SCOPING OPINION:

Proposed London Strategic Heat Main

Case Reference: EN0710009

12 August 2026

0 0.4 0.8 1.2 1.6 2 km

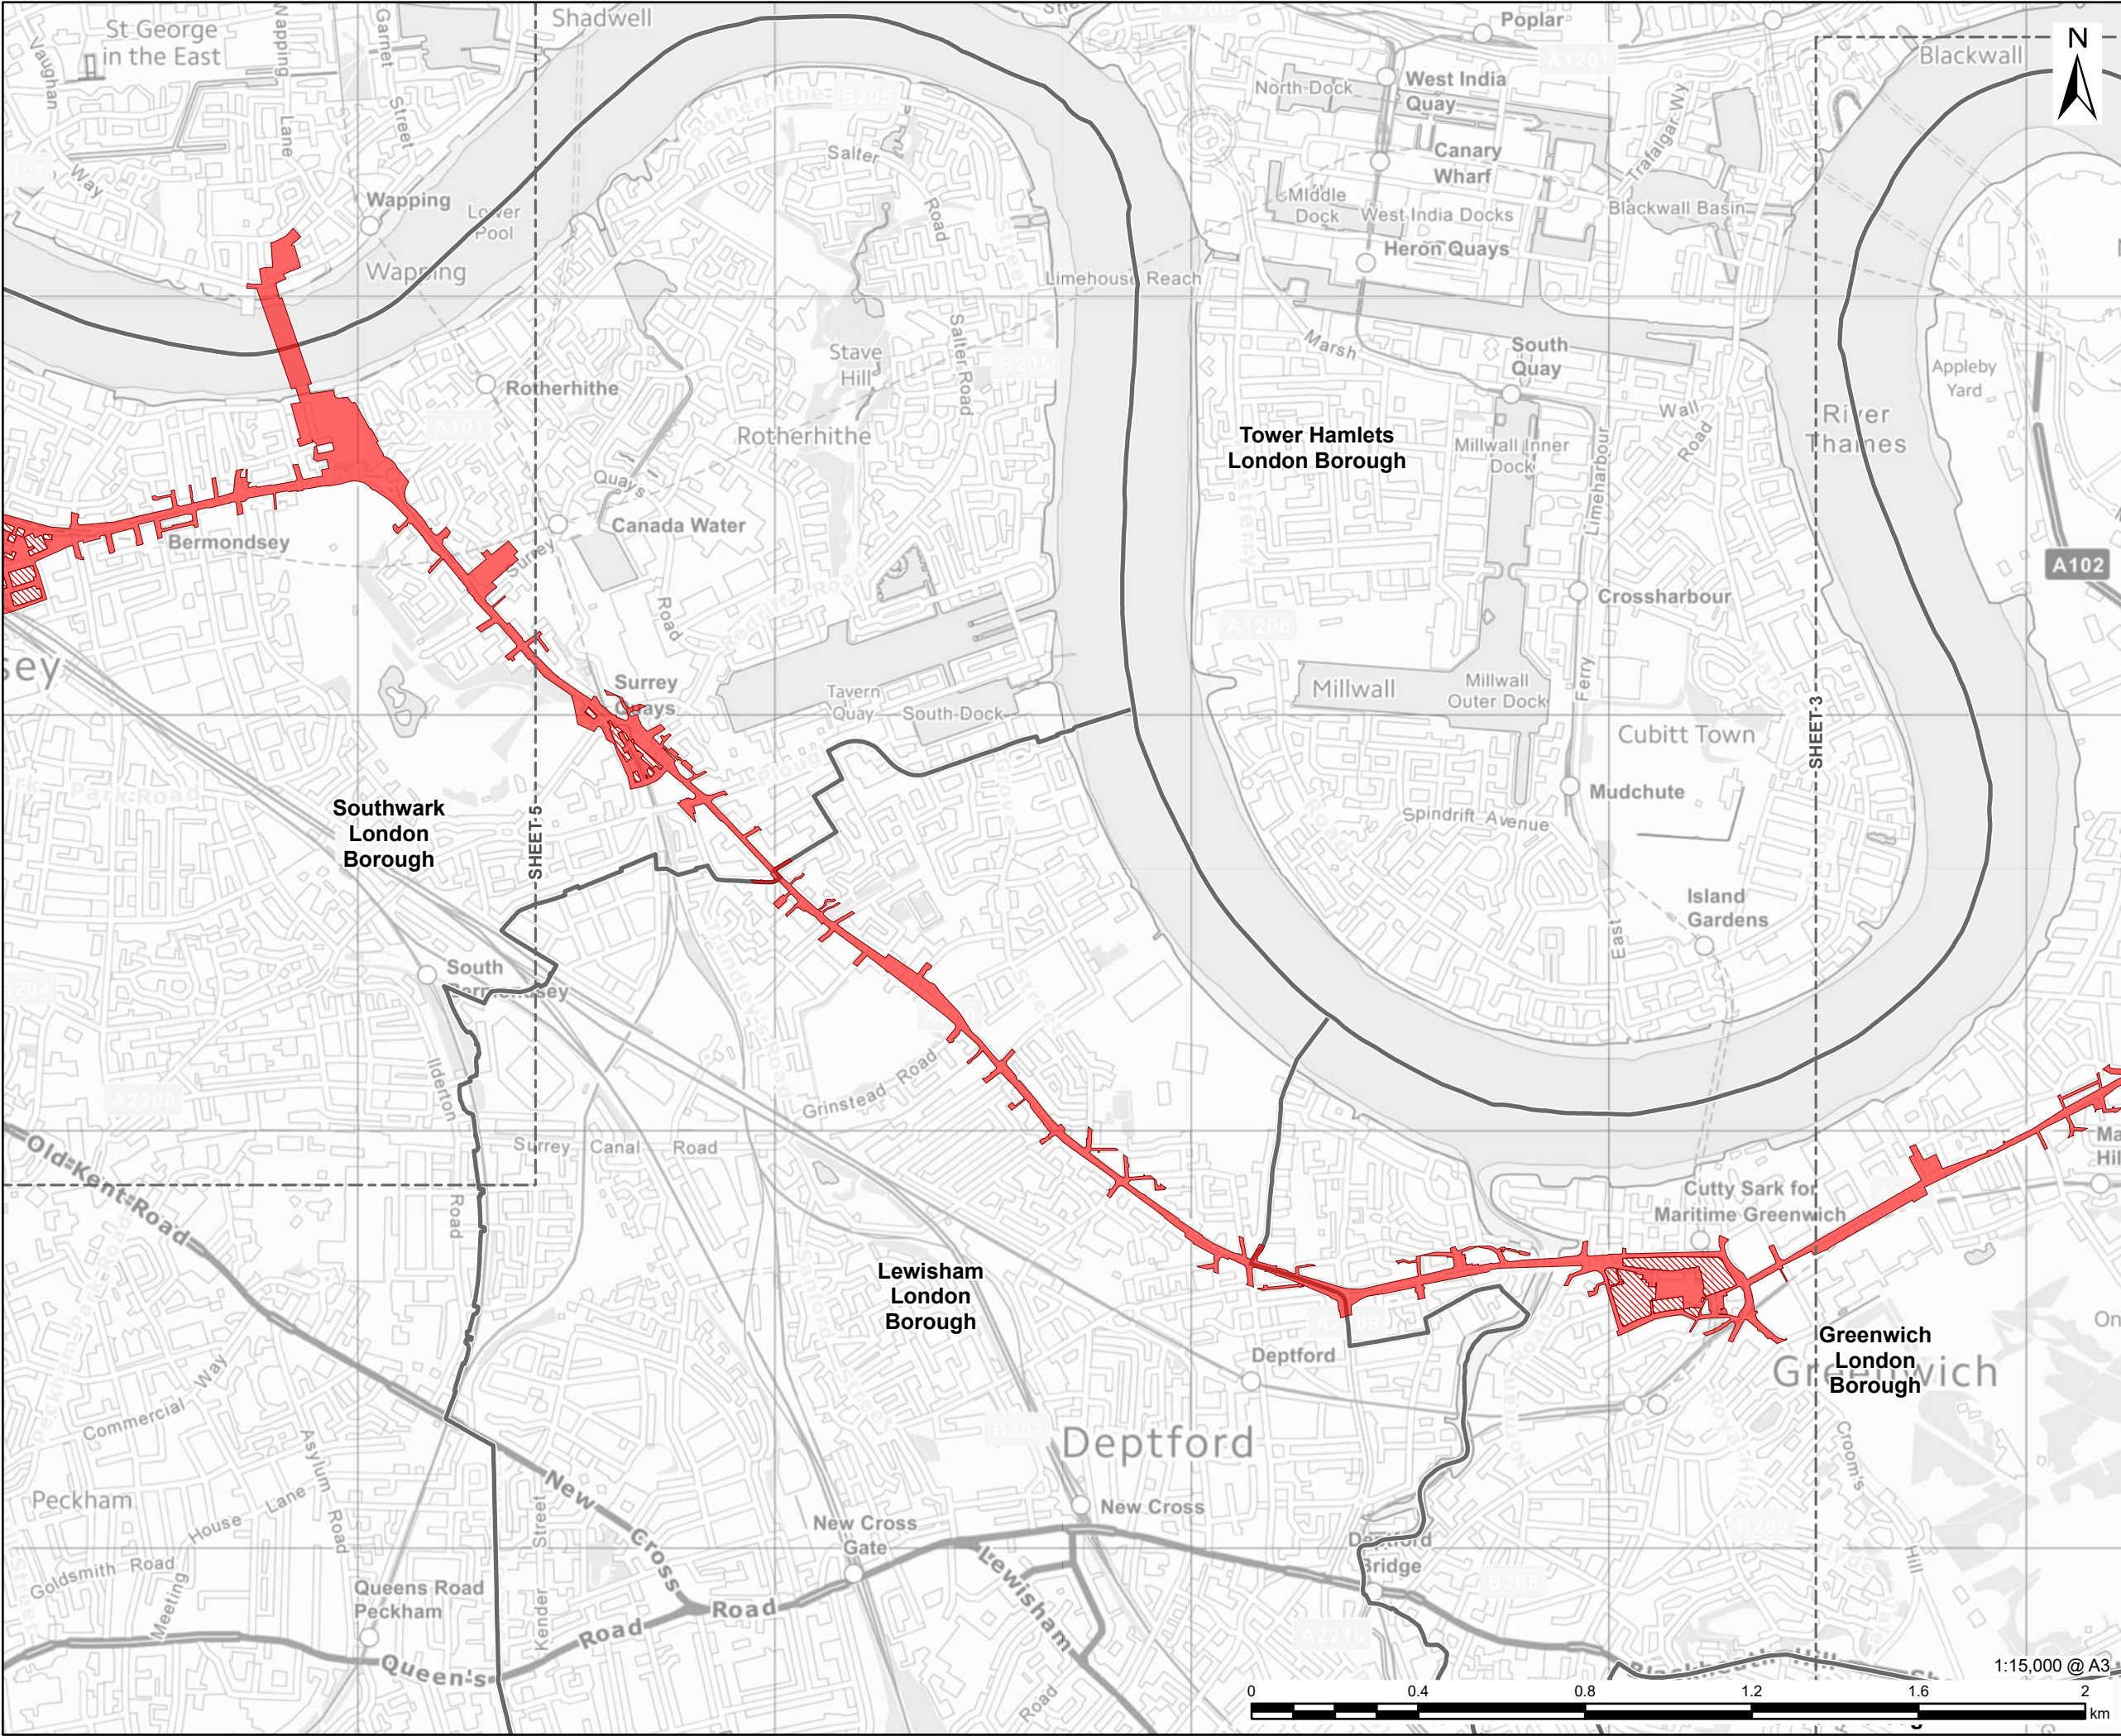
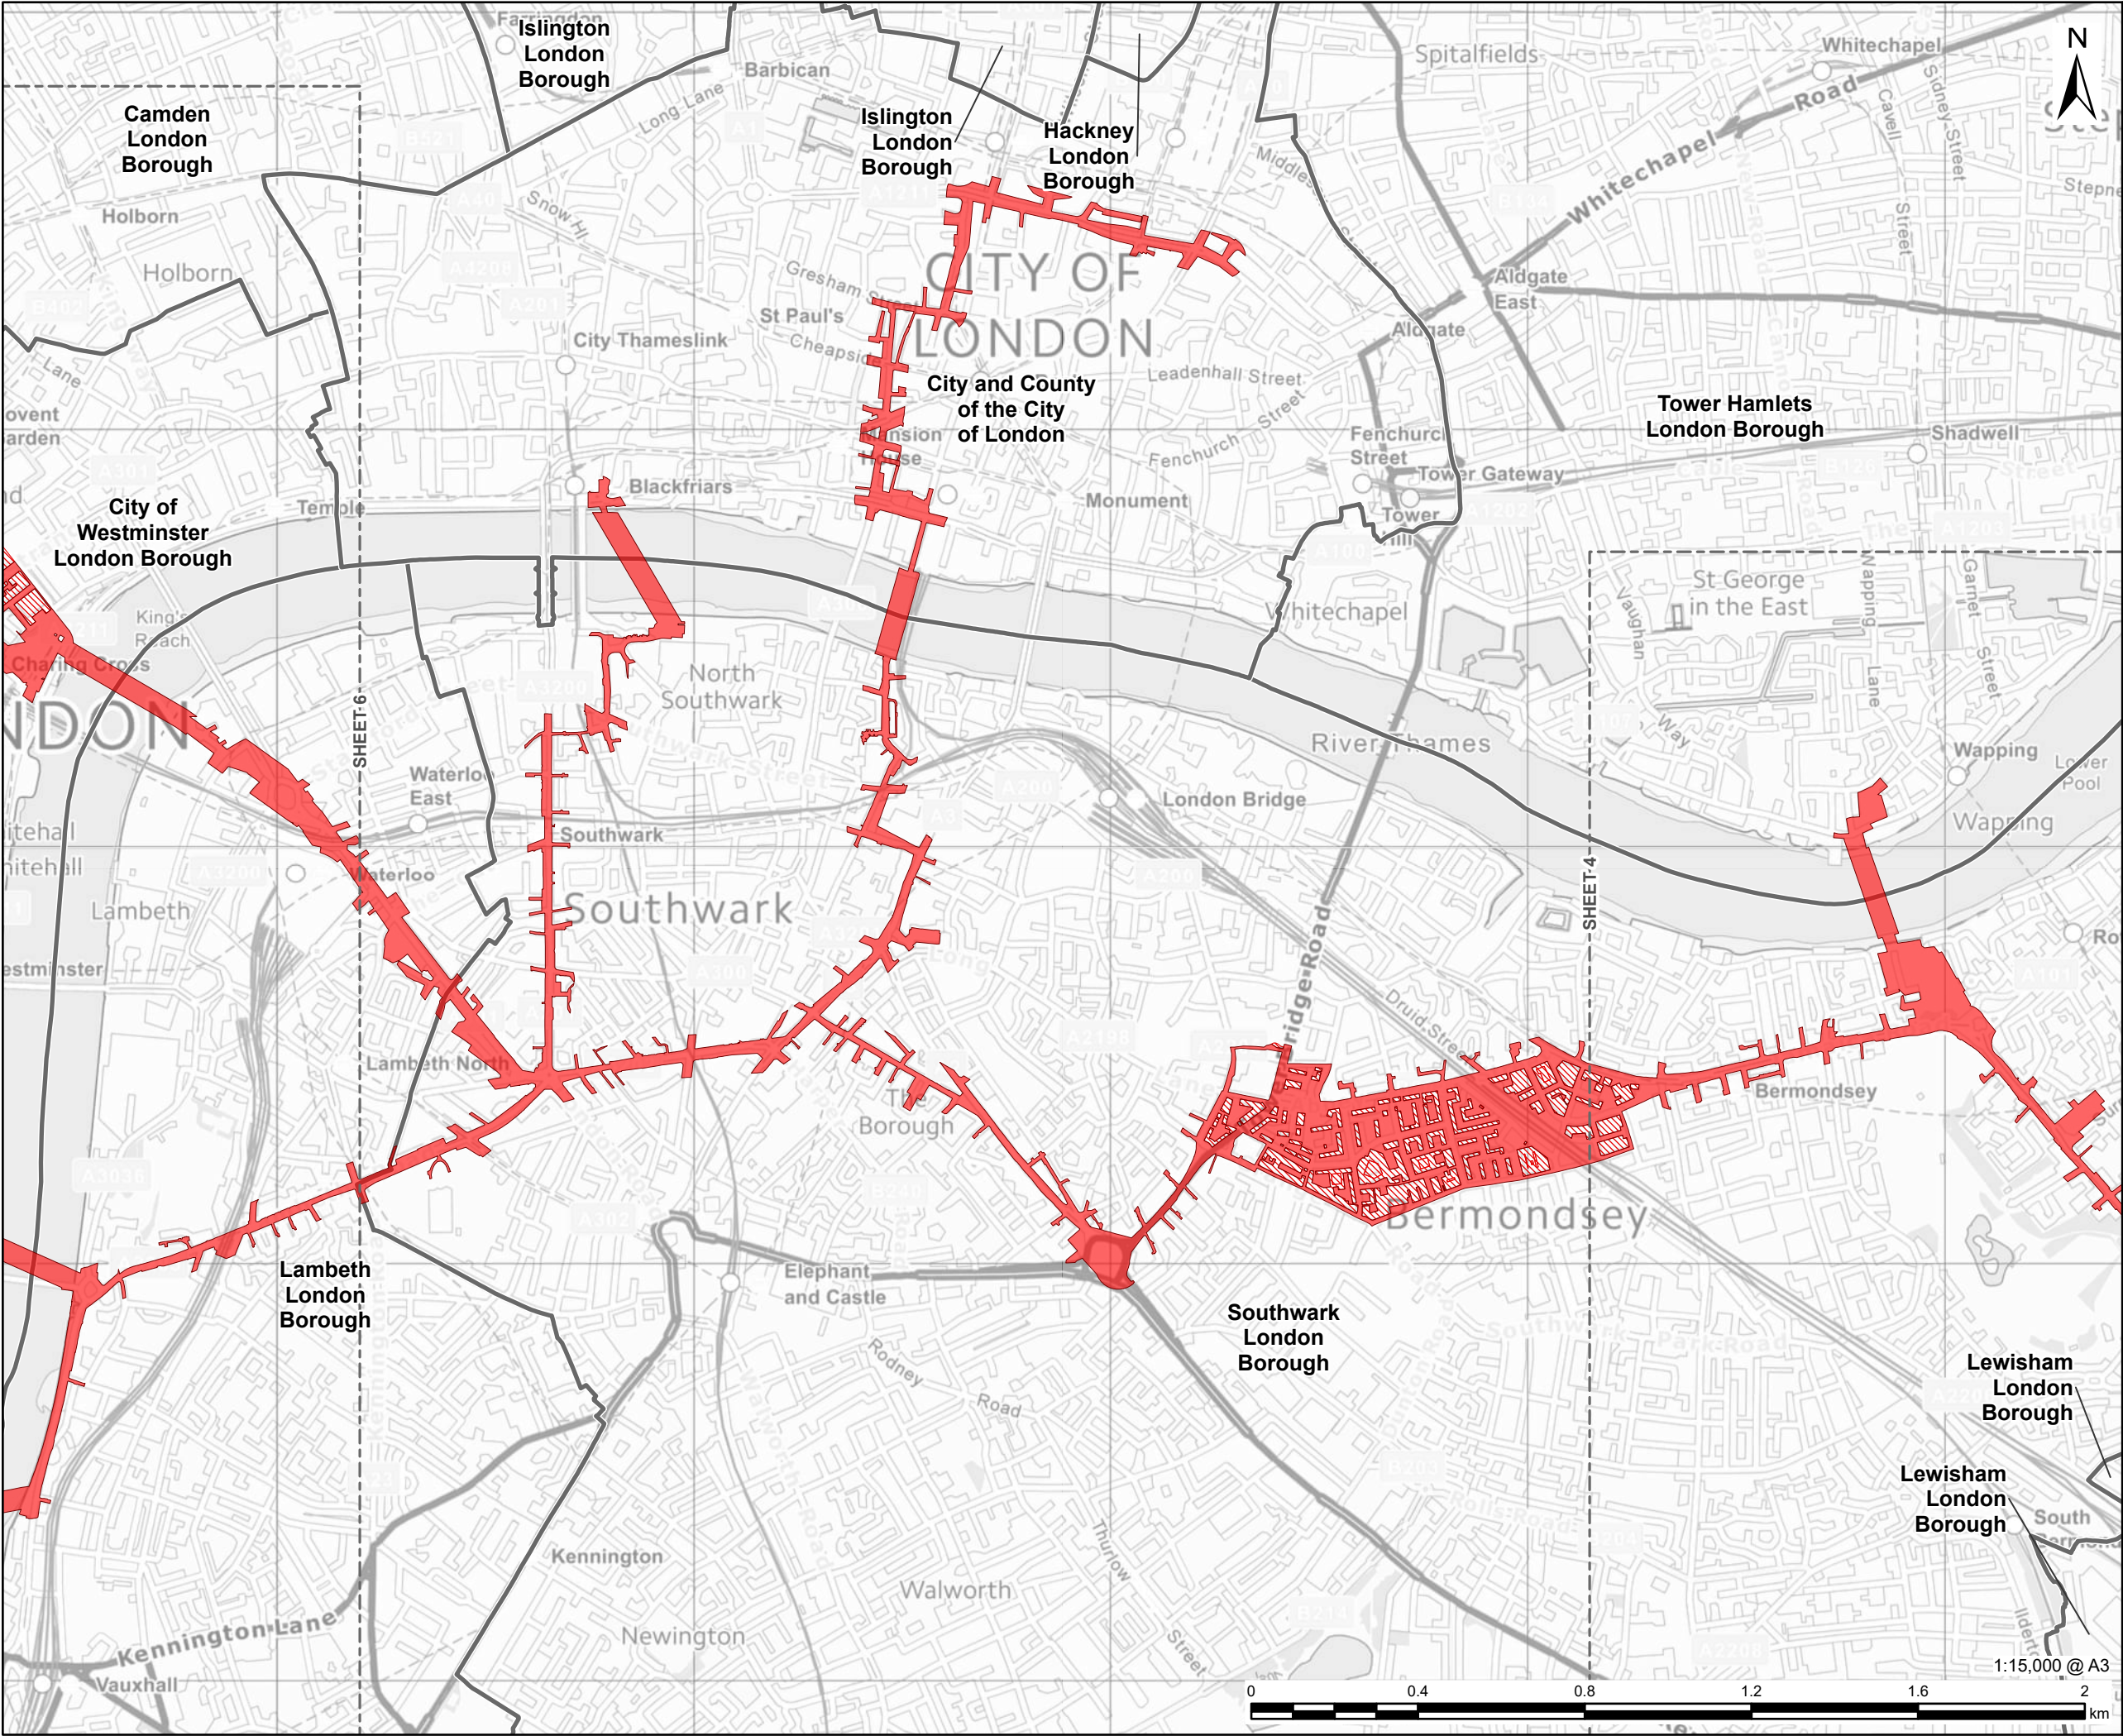
ID	Ref	Description	Inspectorate's comments
2.0.1	Figure 1-1	Scoping Boundary	The applicant should consider whether the figure could show the proposed development order limits within the scoping boundary, this would enable an understanding of the relationship between the proposed development and the scoping boundary. The scoping boundary should also clearly set out where this encroaches into the river Thames itself.

Figure 2-2

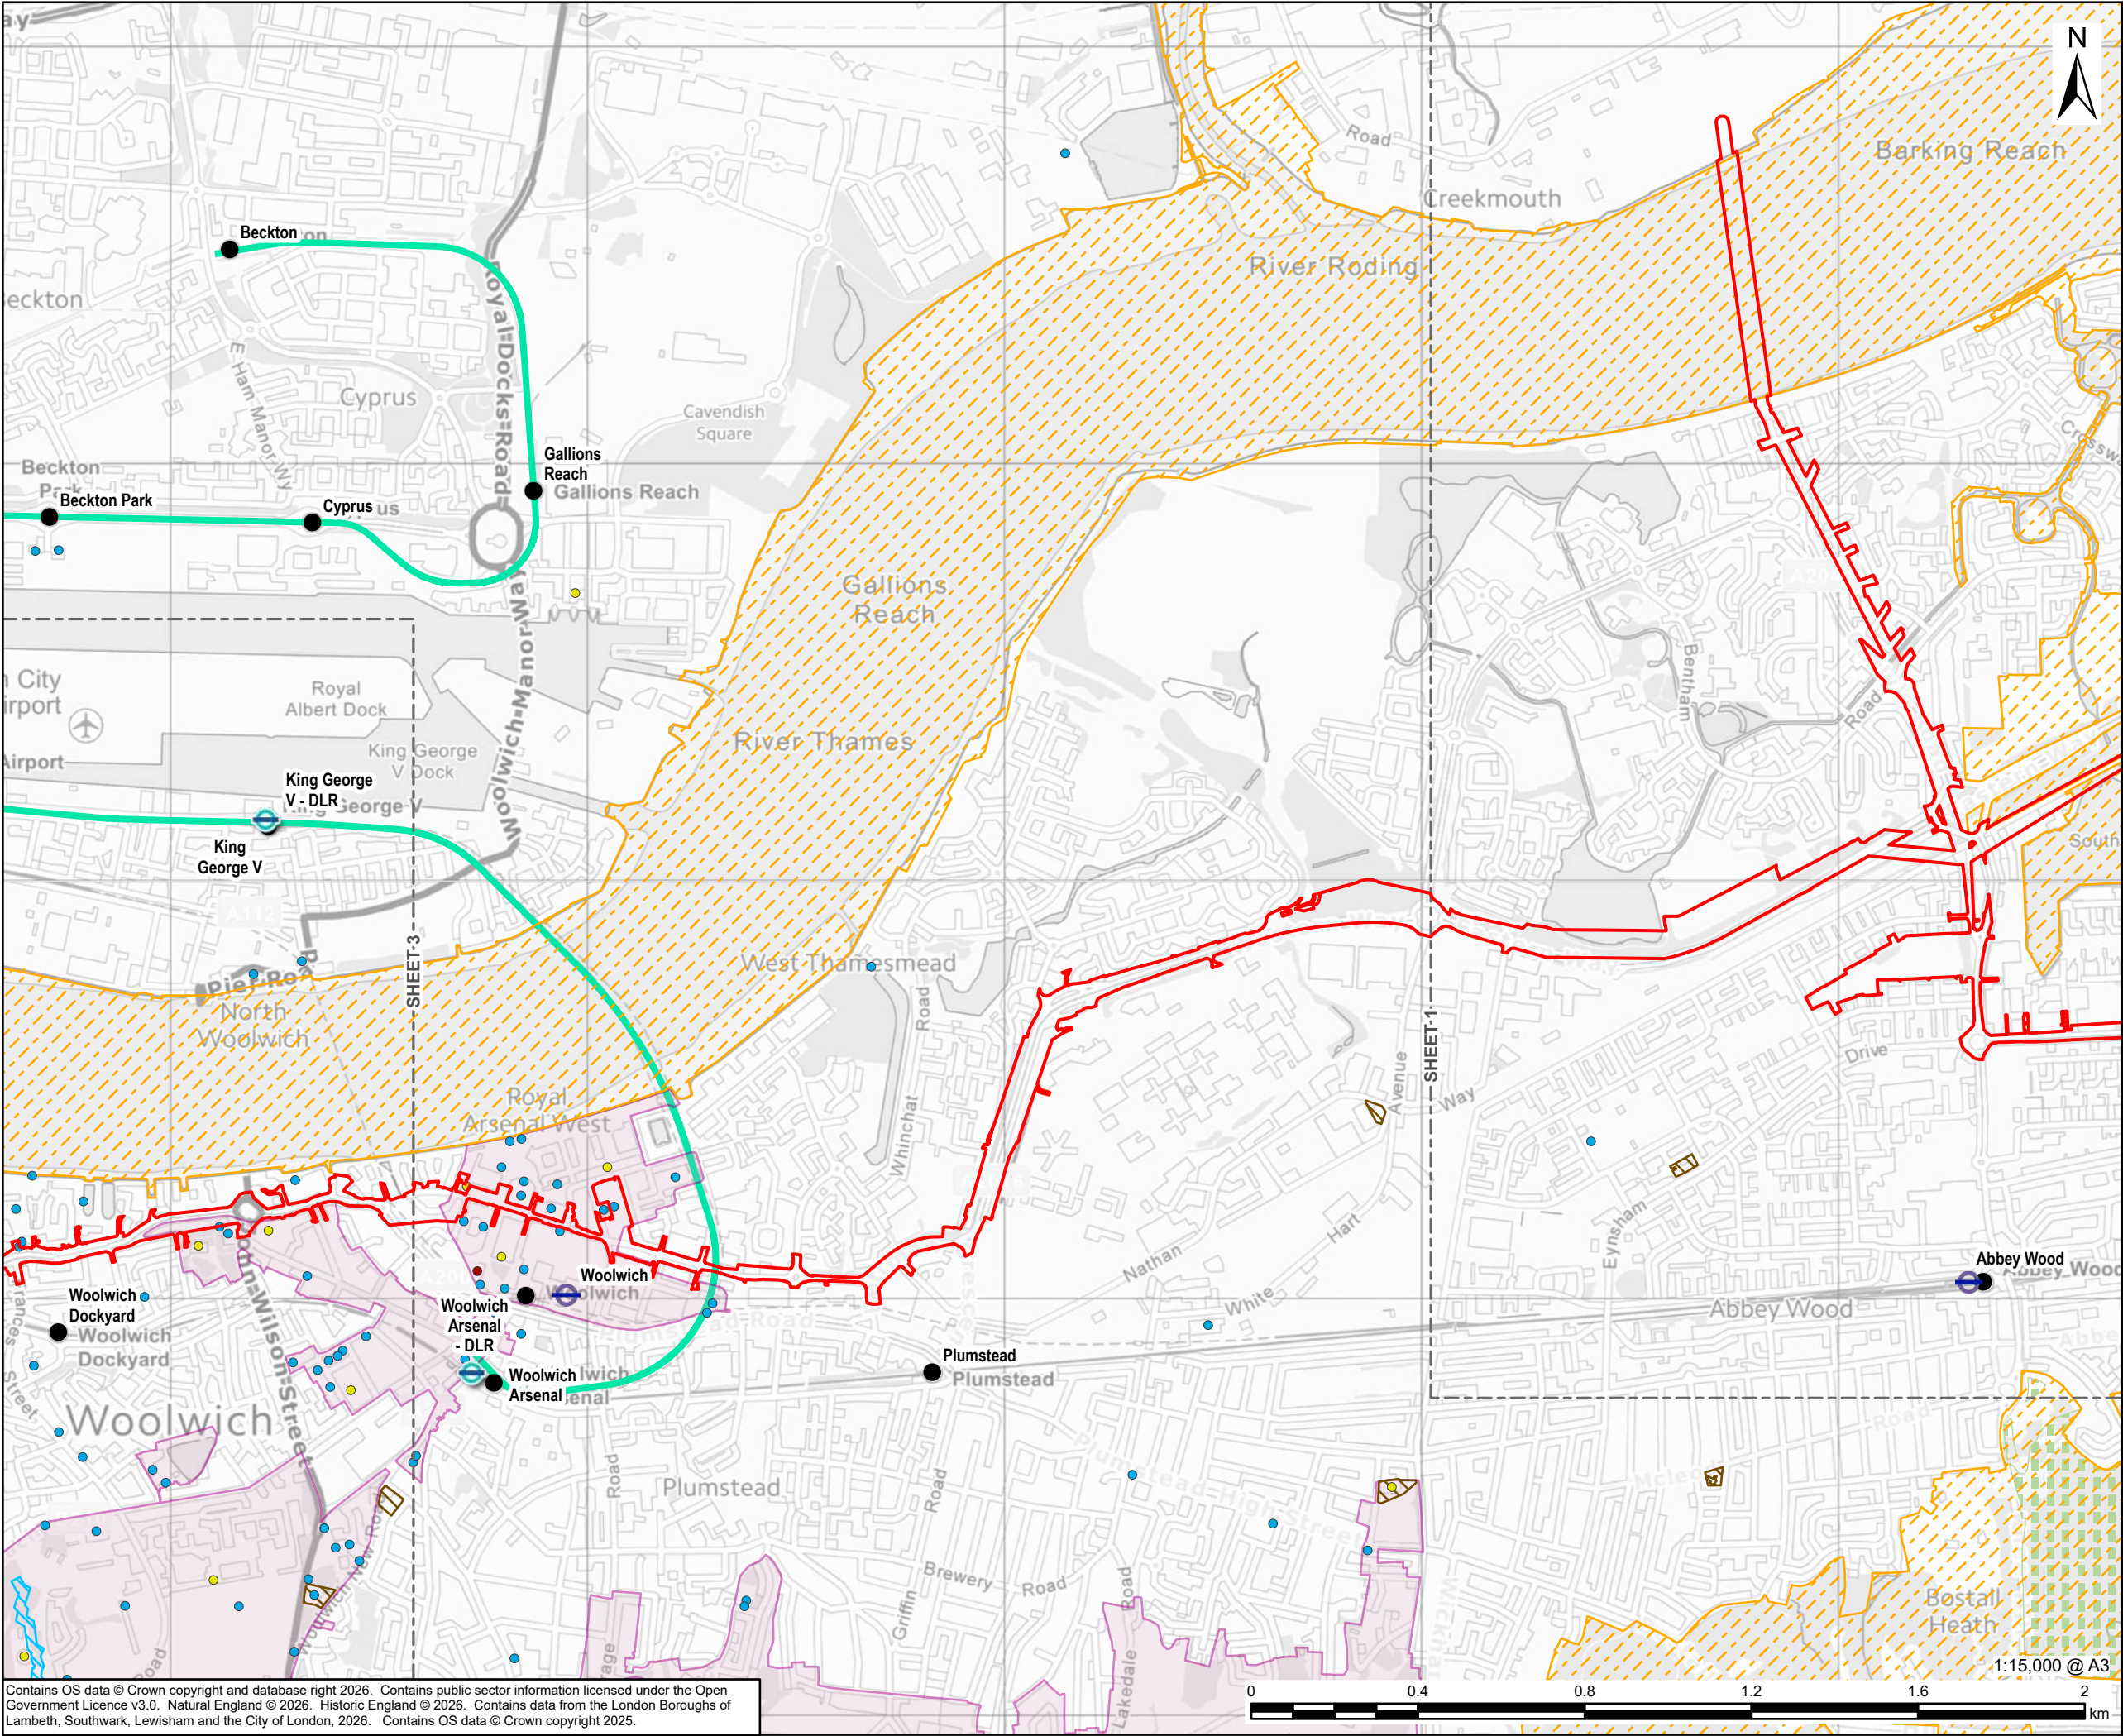
2.1.3	N/A	Consistency of baseline data within figures	There are some minor discrepancies between figures which are intended to represent the same information, for example differences between the listed buildings shown in the Crossness Conservation Area between Figure 2-2 sheet 1 and Figure 10-1 sheet 3. The ES should ensure that figures provide a consistent representation of the baseline or assessment findings.
